Arun District Council
Arun Civic Centre
Maltravers Road
Littlehampton
West Sussex BN17 5LF
Planning & Building Control General Enquiries
Tel: (01903) 737756 Fax: (01903) 730442
Dx: 57406 Littlehampton
Minicom: 01903 732765
e-mail: planning@arun.gov.uk
website: www.arun.gov.uk/planning

Application No: Y/7/22/PL
Site Address: Land adjacent to Bonhams & Flints Hoe Lane Flansham PO22 8NP
Description of works: Erection of 4 No dwelling with access from Hoe Lane and associated landscaping, including native orchards and wildflower meadows. This application is a Departure from the Development Plan and is in CIL zone 3 and is CIL Liable as new dwellings.

Thank you for your internet representation made on 1st March 2022 which has been recorded as no objection with the comments as follows:

1 GROUND FLOOR PLAN
Scale: 1:100

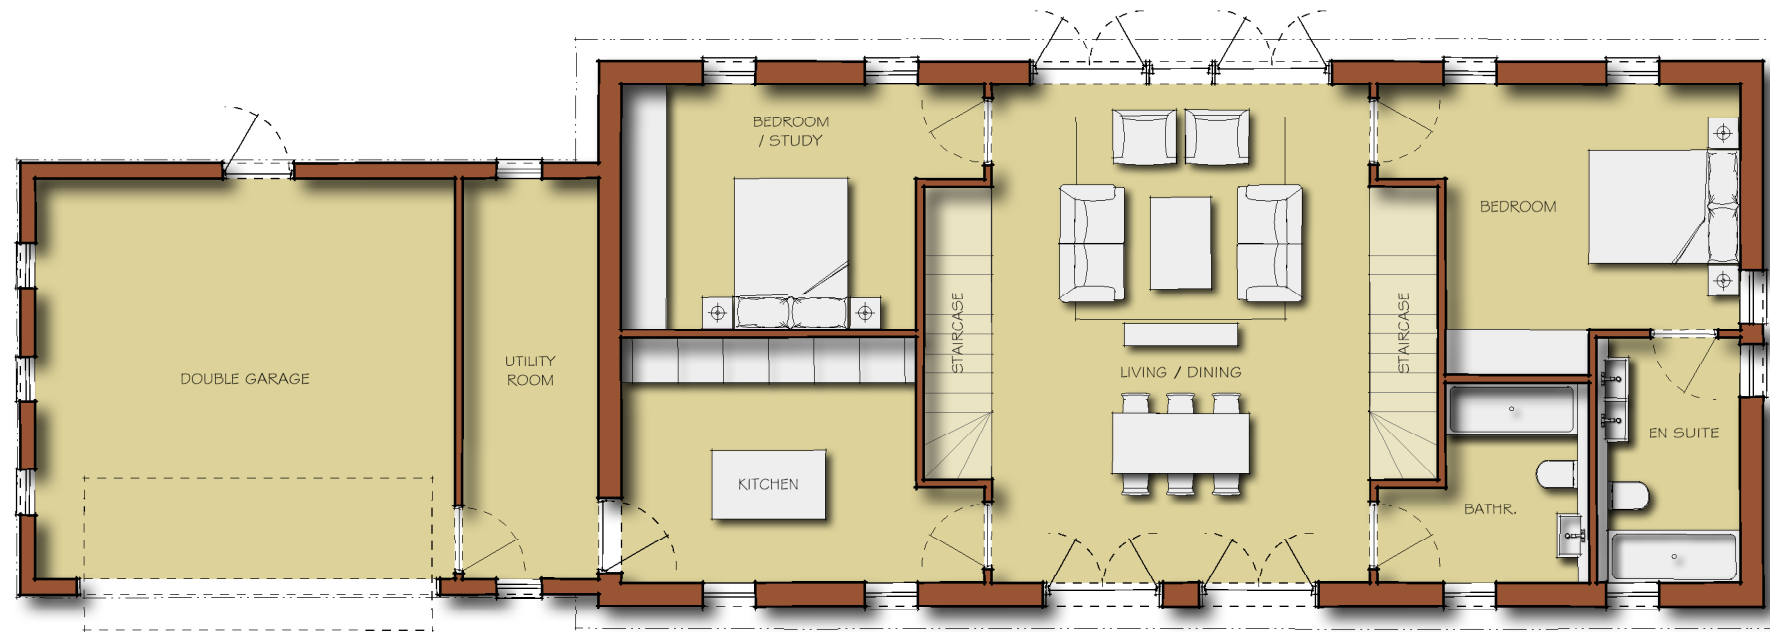
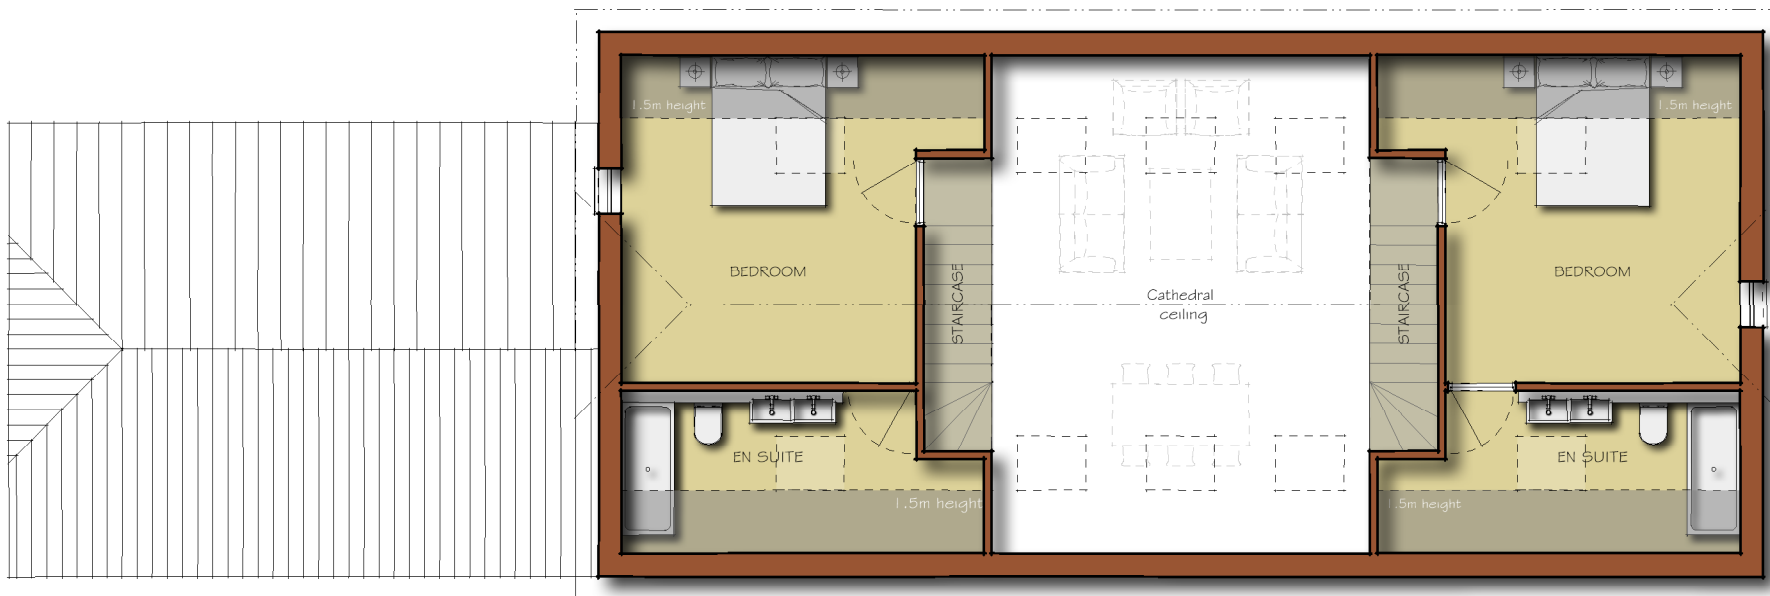
Finally, we have also discussed two "overlooking windows" with Victor - these are the two end windows that

are within the bedrooms of the house closest to the Bonhams boundary. While we are not 100% sure (because we cannot see exact positioning or scale in the rooms) we believe these do allow direct viewing into our garden and have asked that these be made higher within the bedroom to avoid this. We also appreciate that there is some distance between the house and our boundary , but would ask that you do look into these two windows.
